Recommendation Report for Planning Permission for Works or Extension to a Dwelling

REF NO: FP/63/20/HH

LOCATION: 58 Glynde Crescent
Felpham
PO22 8HT

PROPOSAL: First floor extension above garage.

PROPOSED FIRST FLOOR PLAN

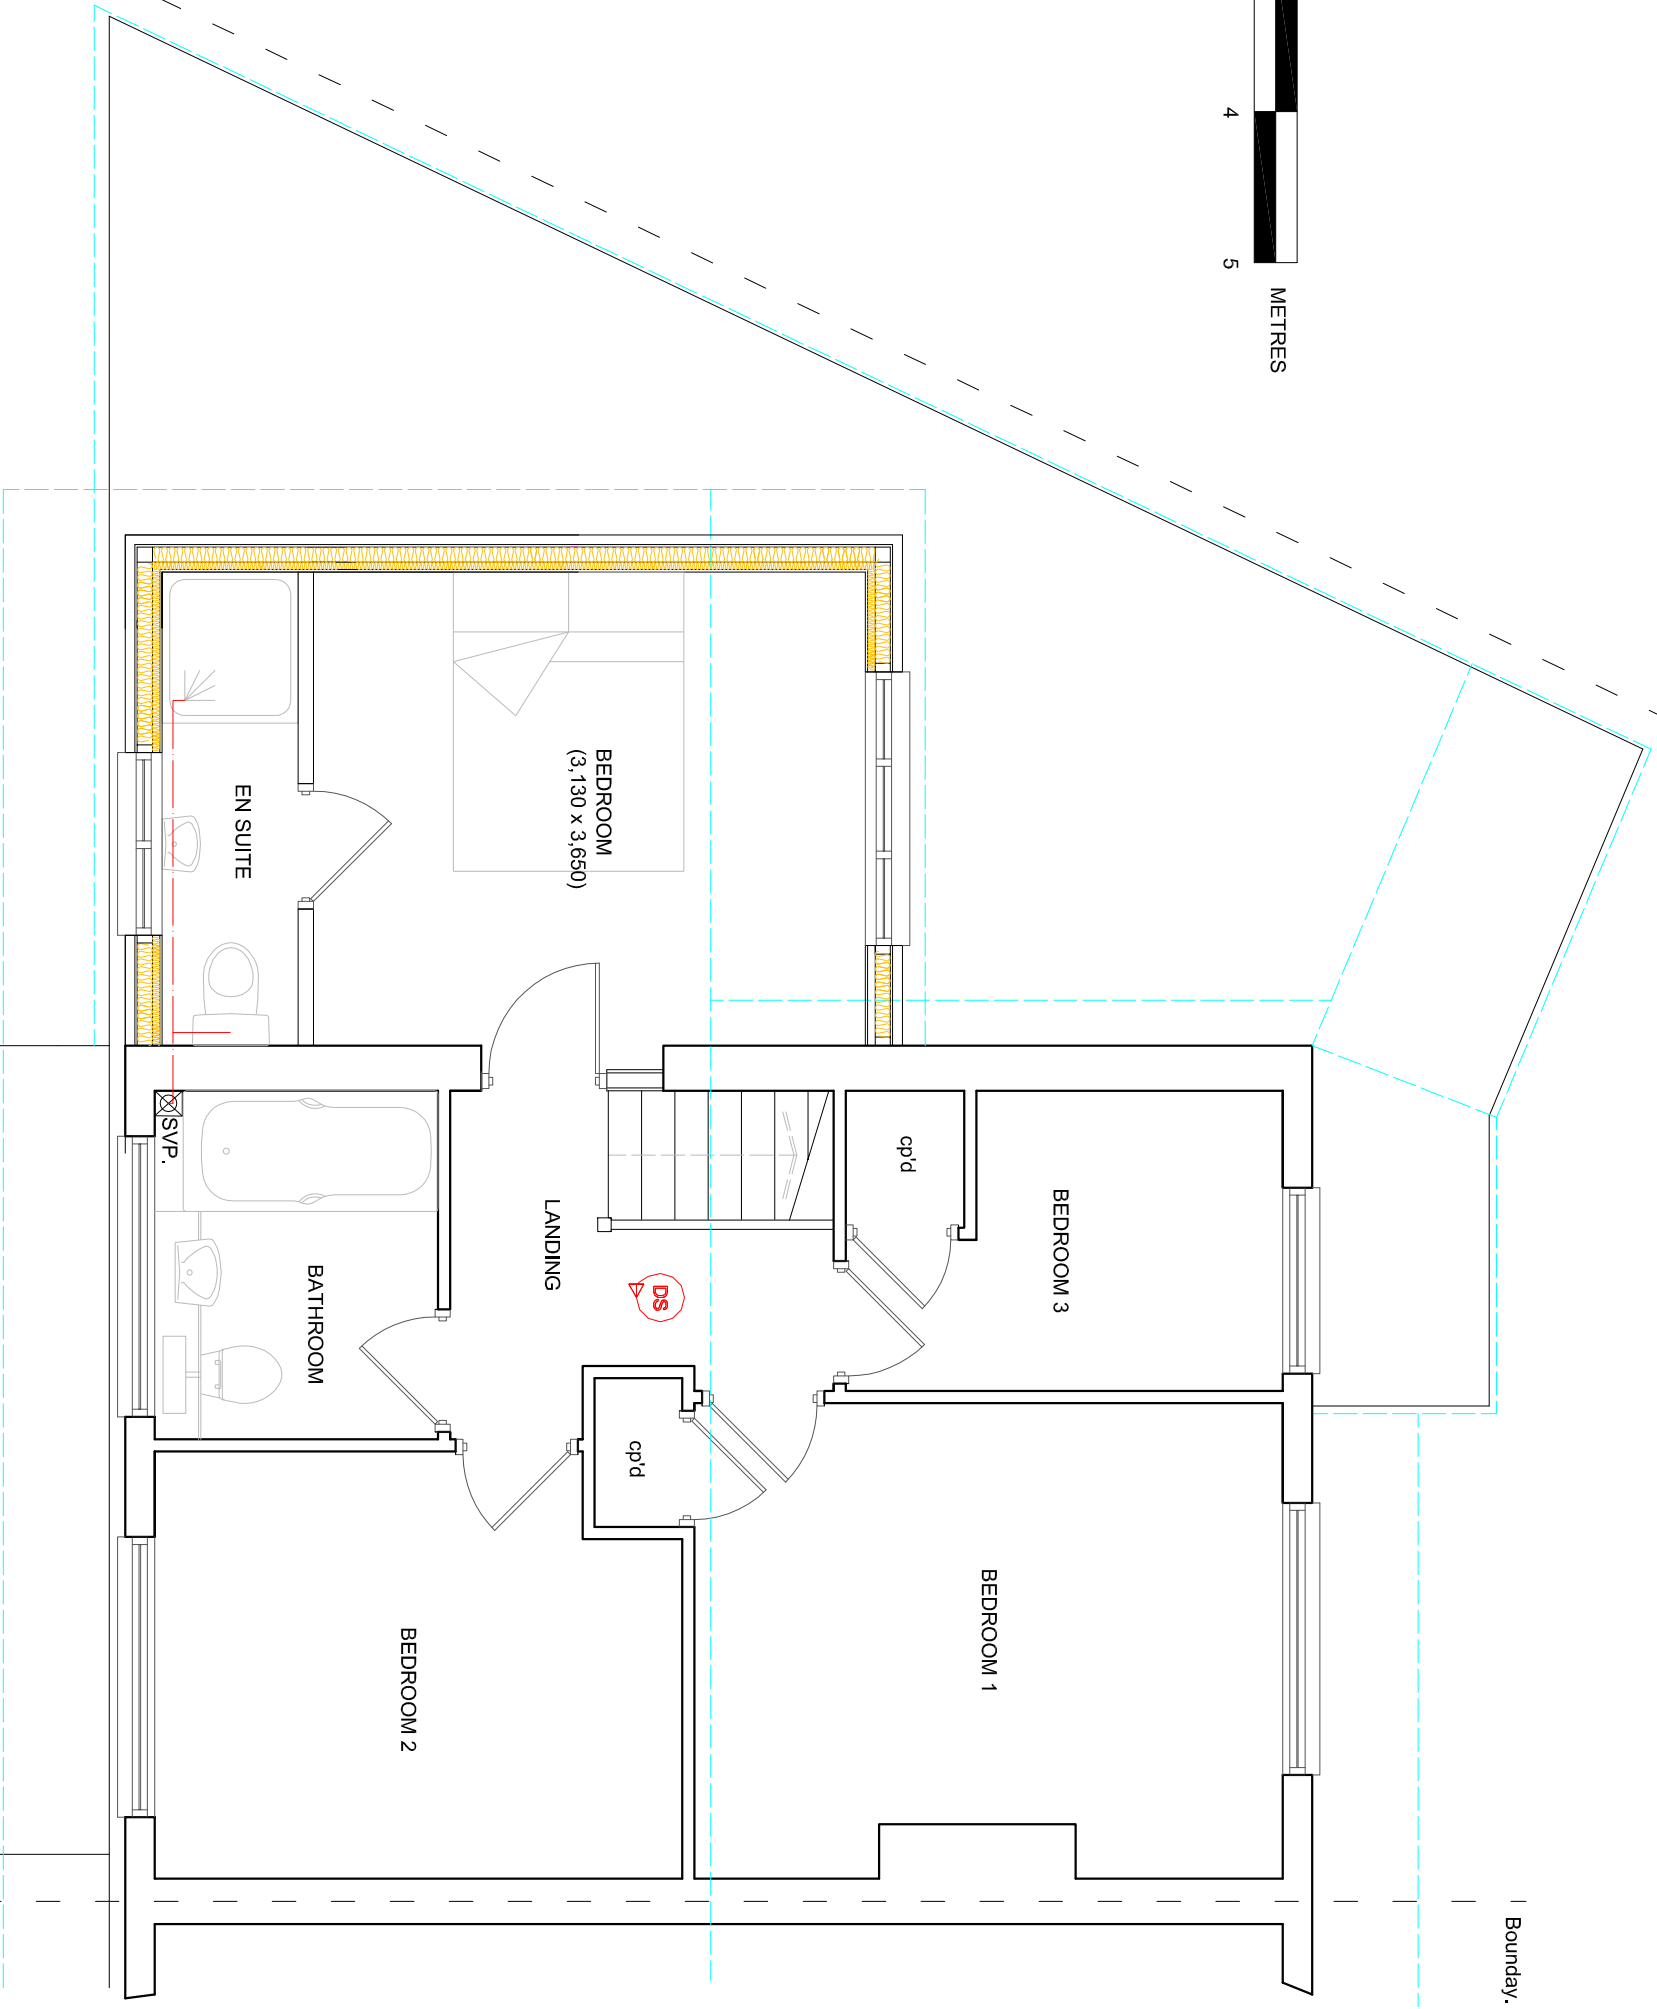
Due to the siting of the extension to the top of the garage it is not considered to give rise to adverse overbearing or overshadowing impacts retaining 14m to the front and 8.8m to the rear boundary whilst maintaining 1m to the side boundary.

PROPOSED ELEVATIONS

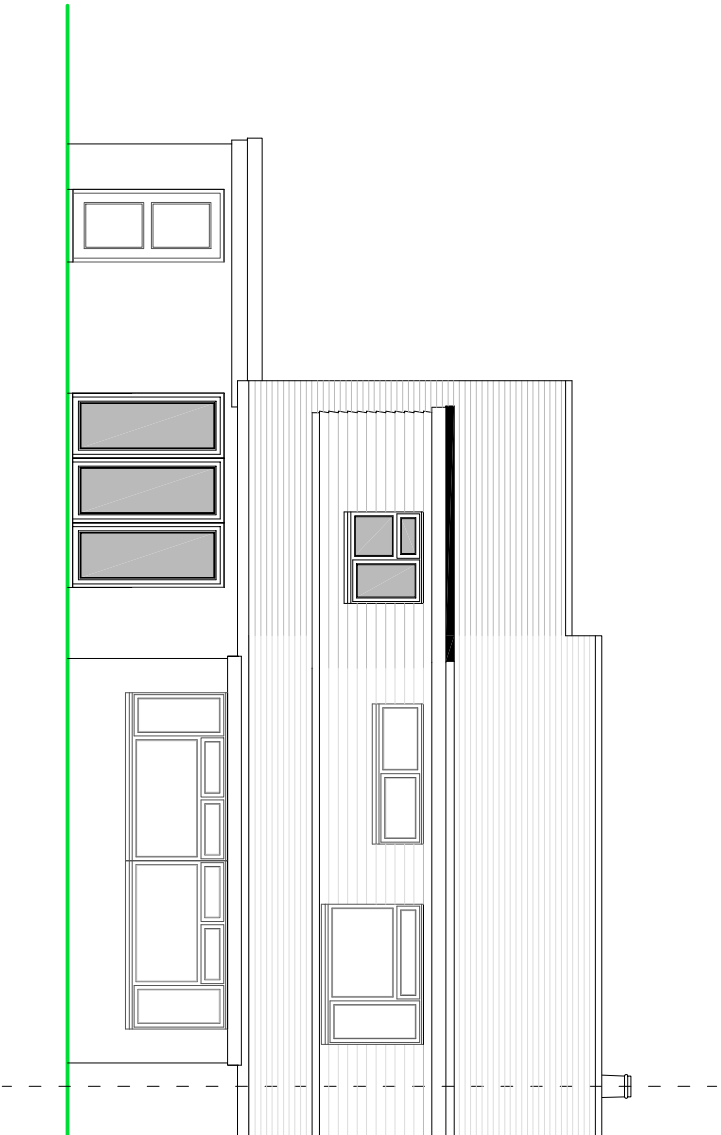
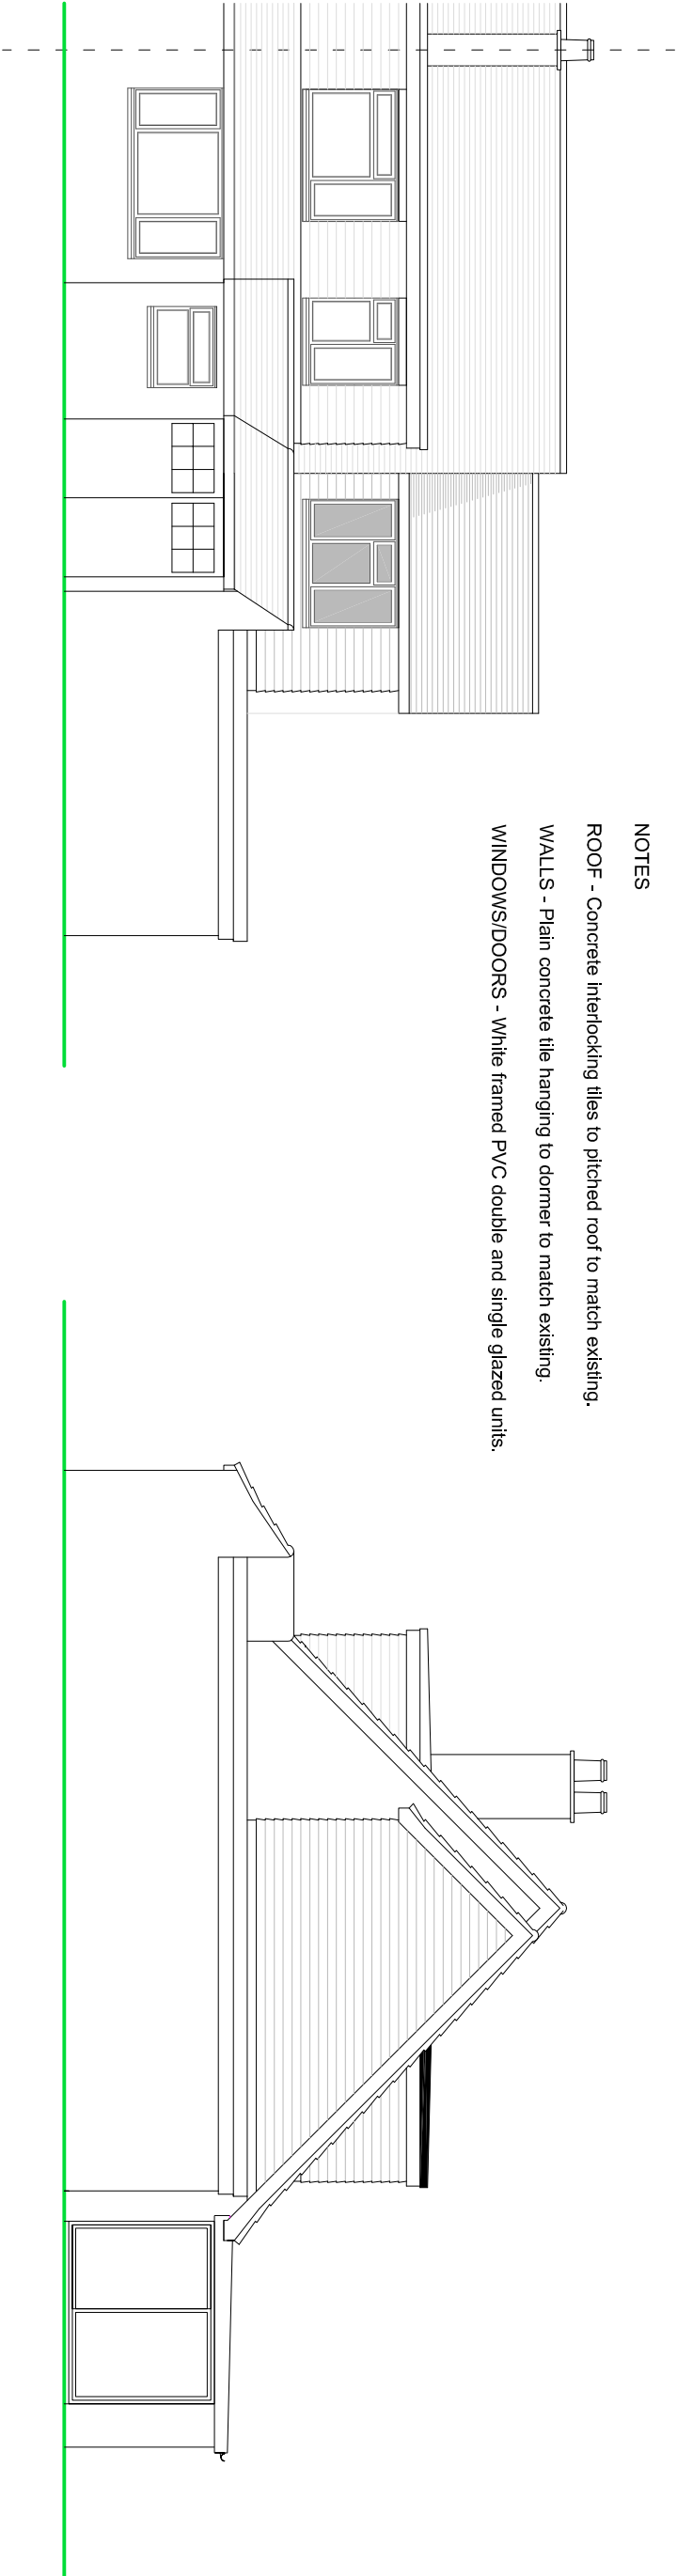
The extension will have a depth of around 5.5m with a height of 6.7m with a pitched roof ending below that of the host dwelling. Eaves will match the dwelling to the rear and match the flat roof to the front. Whilst this adds bulk to the front of the property, it is not considered to appear as an unduly dominant feature to the front elevation and is acceptably integrated into the host dwelling.

The materials will match of the house and appear well integrated.

There will be a window to the west elevation, however it will not harmfully overlook given the location of this window at an oblique angle in relation to the neighbouring dwelling and that there are other windows similarly positioned on the first floor of the host dwelling. There will be a window to the east within 10m from the boundary. However these are views towards the front of the neighbouring dwelling where there are existing windows already offering views and so is no more harmful.
